Tween Bridge Solar Farm

8.26 Applicant Response to Deadline 4 Submissions

Document Reference: 8.26

Deadline 5 August 2026

Figure 2 : 16413_P19_Post Development Habitats_TLR_RR

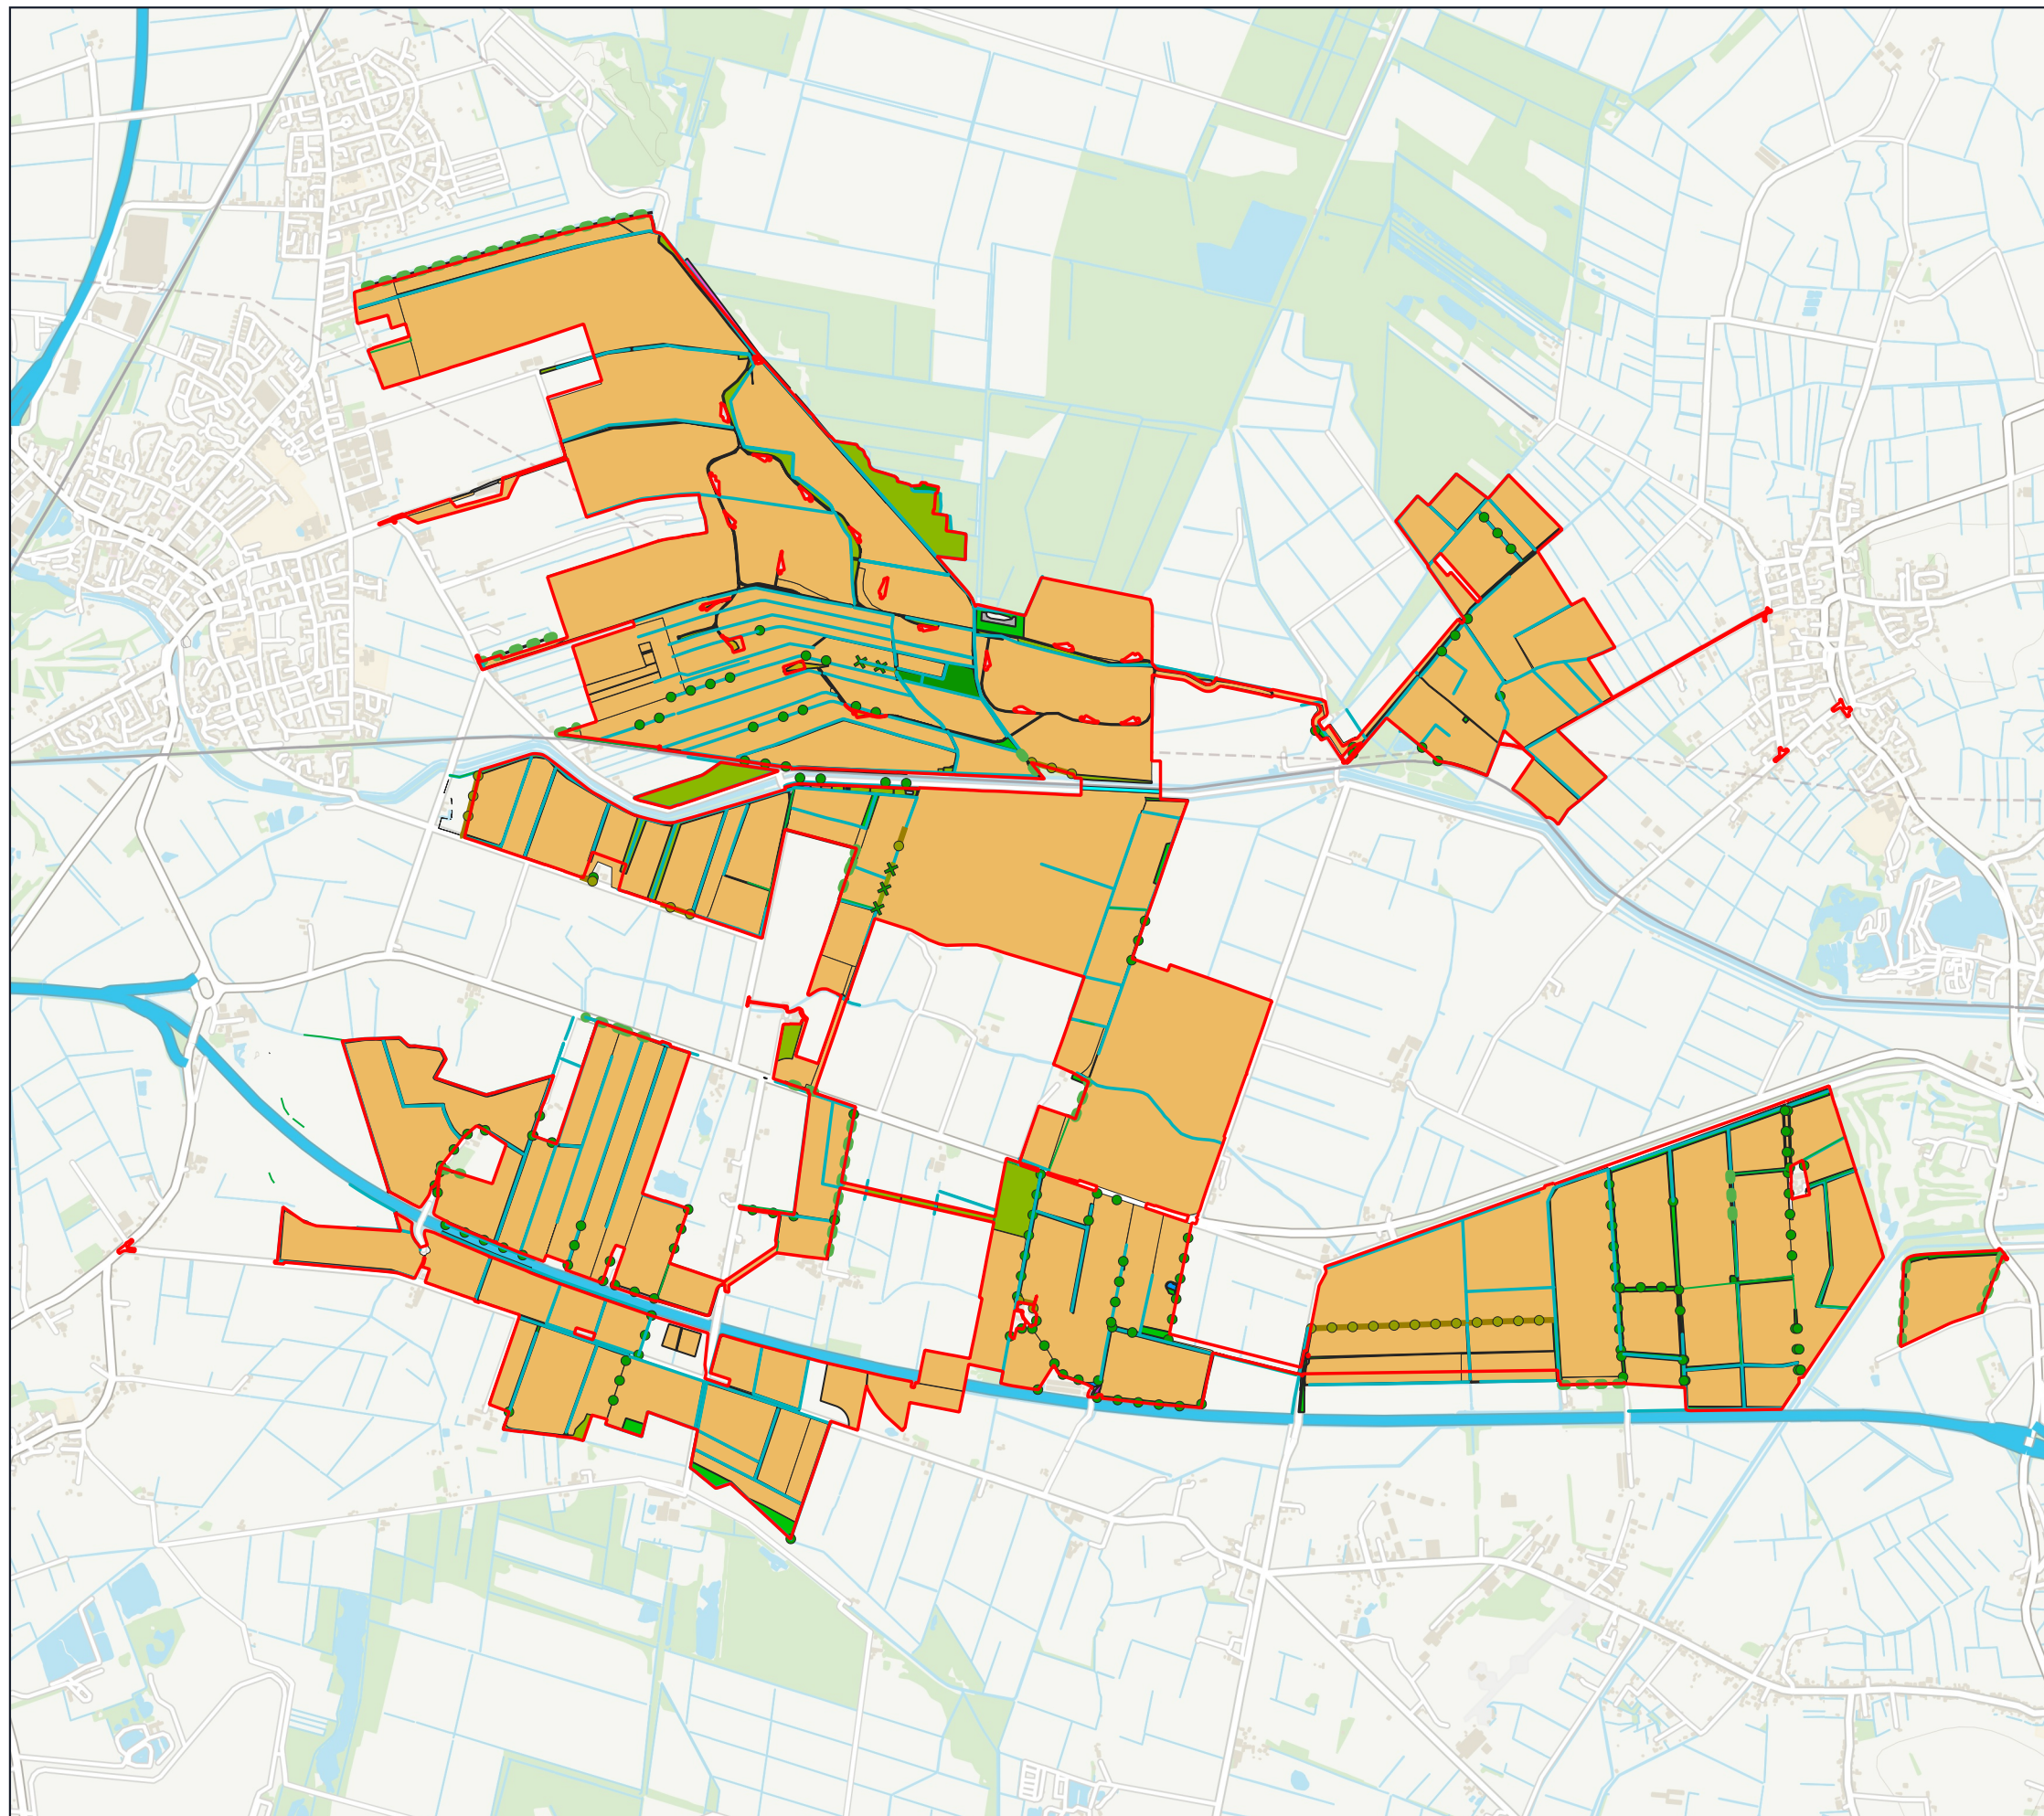
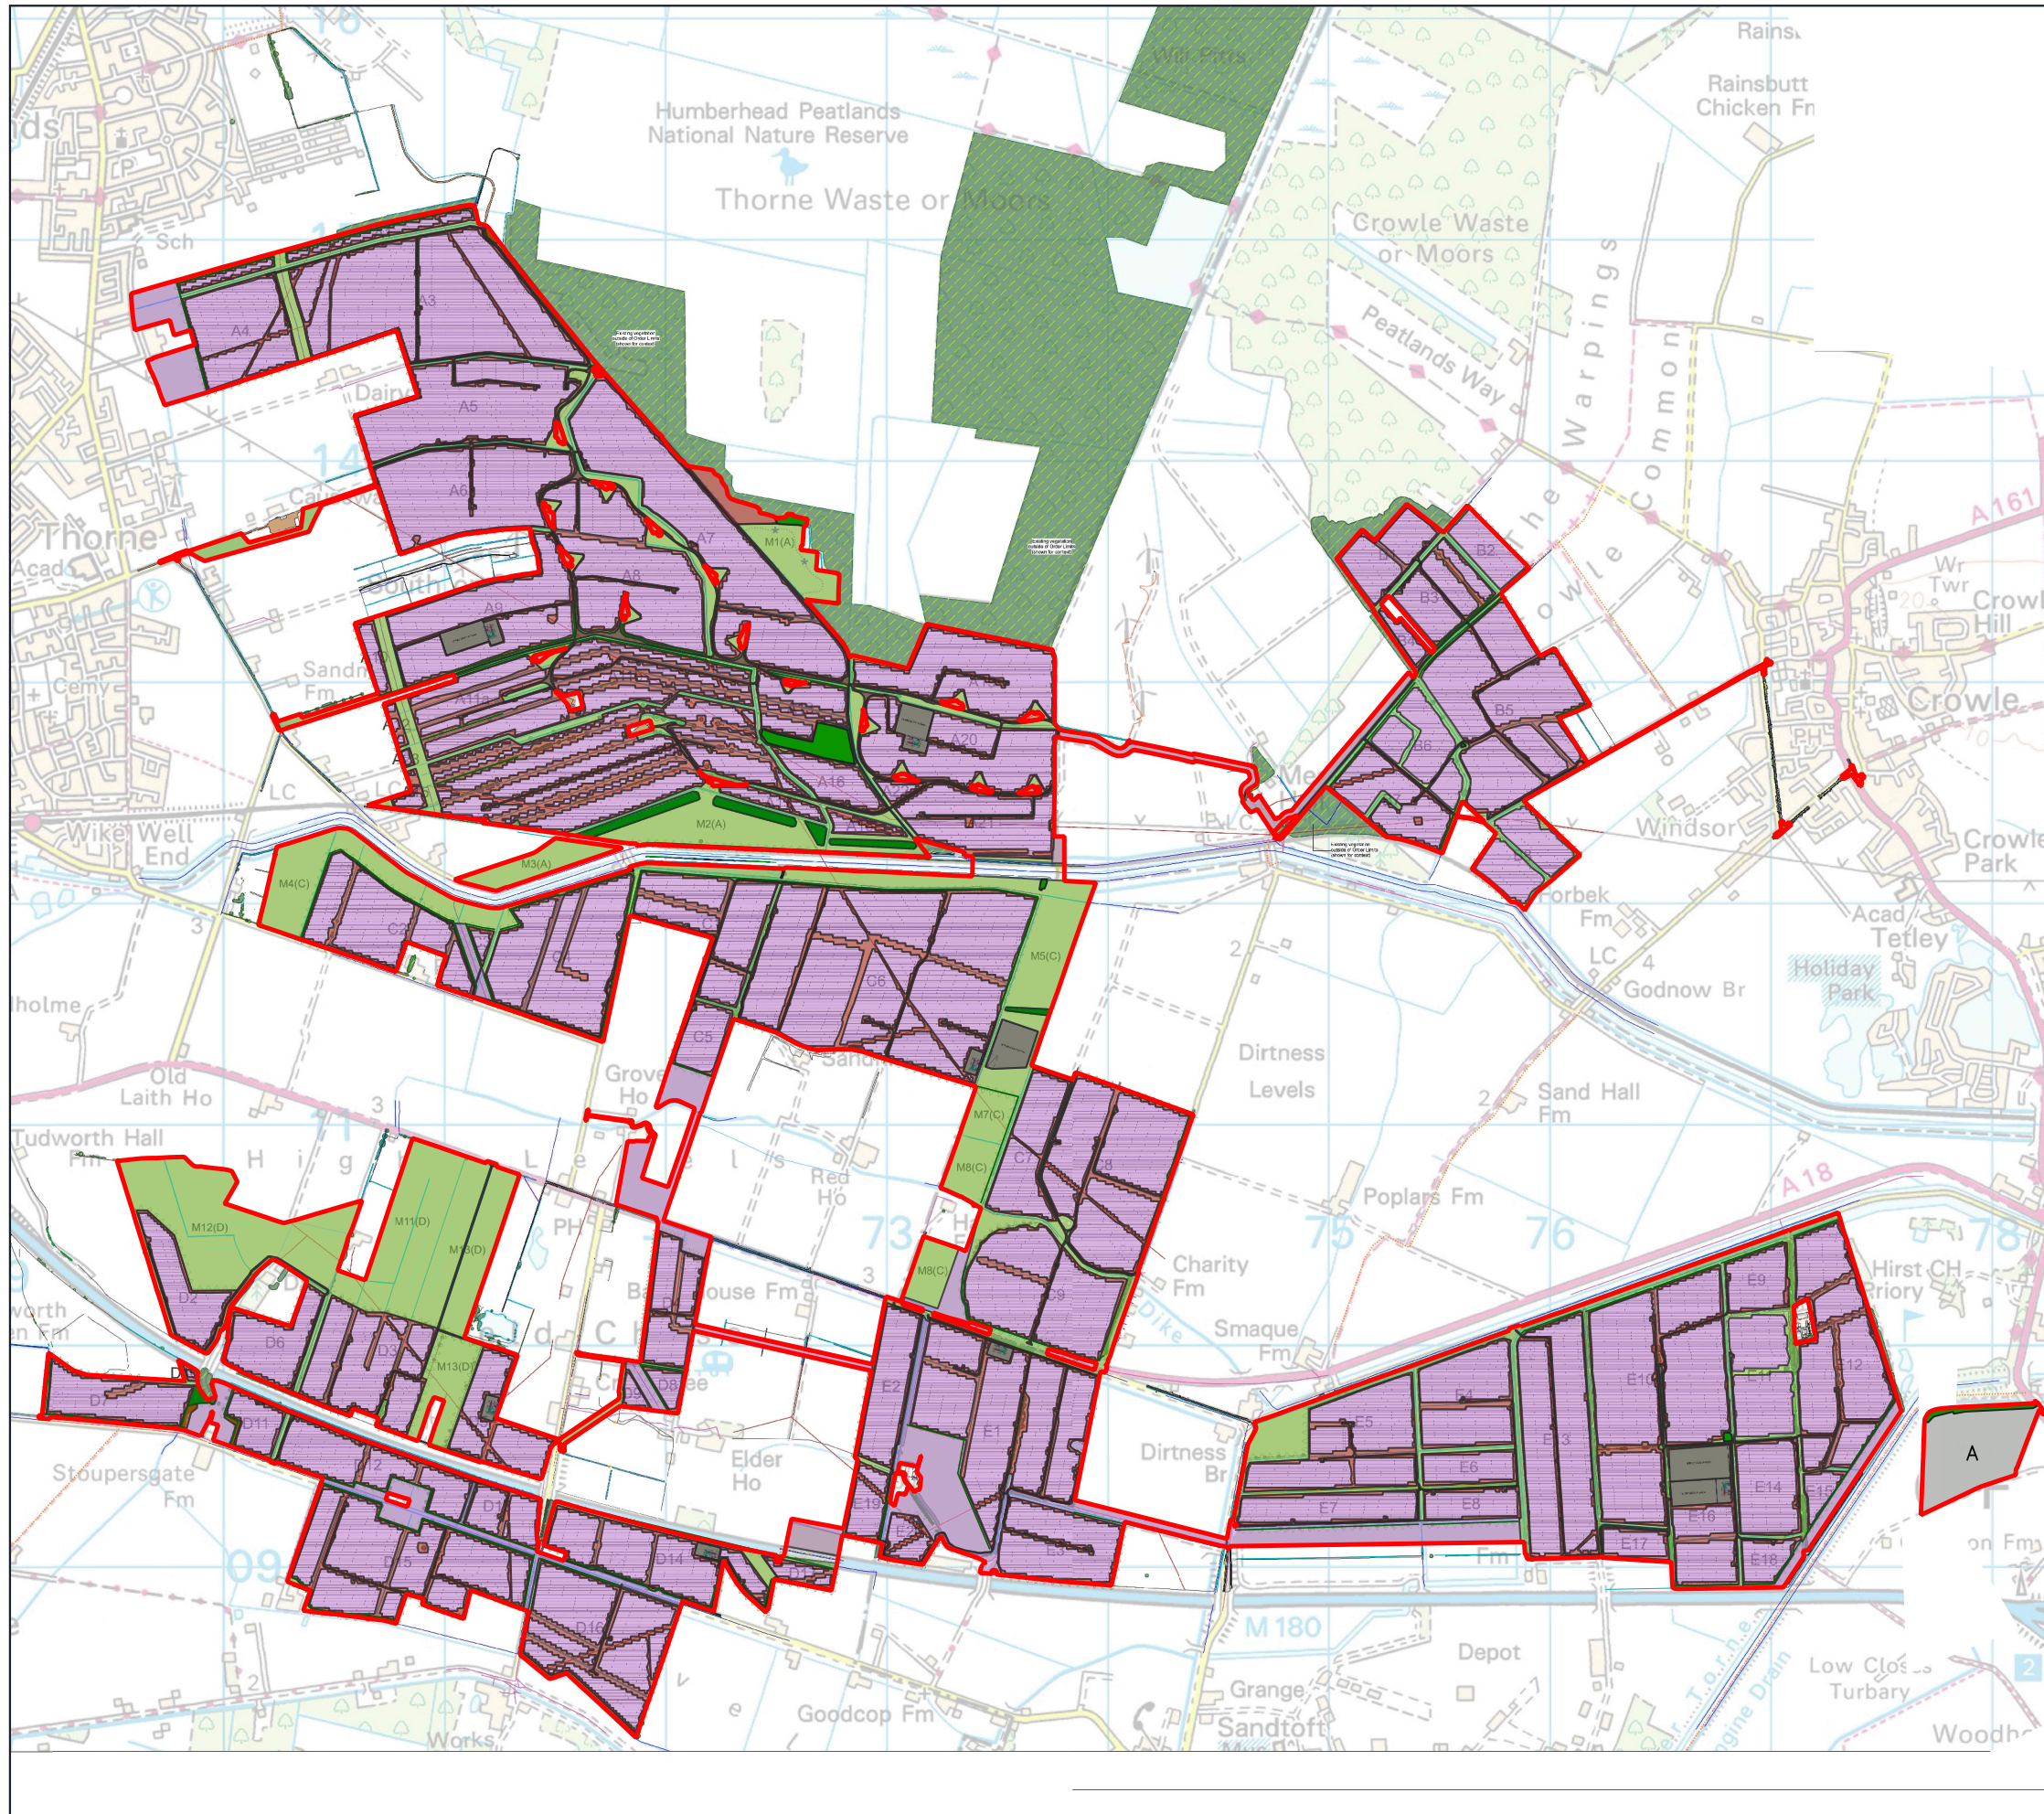
3.3	As noted in our Deadline 2 Written Representations [REP2-102], it is unclear whether the BNG Metric is complete due to there being no information on the Watercourse Creation tab. We consider it likely that additional enhancements may be required to ensure delivery of 10% net gain for watercourses.	The Environment Agency's comment regarding the absence of information from the Watercourse Creation tab relates to the superseded Change Request 1 metric. The Watercourse Creation tab within the current updated metric – [REP3-028], has been completed and records the creation of 0.625 km of culvert associated with the 125 proposed new crossings. The corresponding 0.625 km of

existing ditch is recorded as lost within the watercourse calculations. The current metric also includes the proposed enhancement of the retained ditch network. As confirmed by paragraph 3.34 and Figure 4.1 of the Environmental Statement Appendix 7.12: Biodiversity Net Gain Assessment [REP3-028], the completed watercourse module demonstrates a gain of 99.39 watercourse units, equivalent to a watercourse net gain of 10.26%. The Watercourse Creation tab is therefore complete, the proposed culvert impacts have been accounted for, and the metric demonstrates that over 10% watercourse net gain will be achieved. No additional watercourse enhancement is required.
4.0 Detailed Unexploded Ordnance Risk Assessment (Rev 1) [REP3-030]
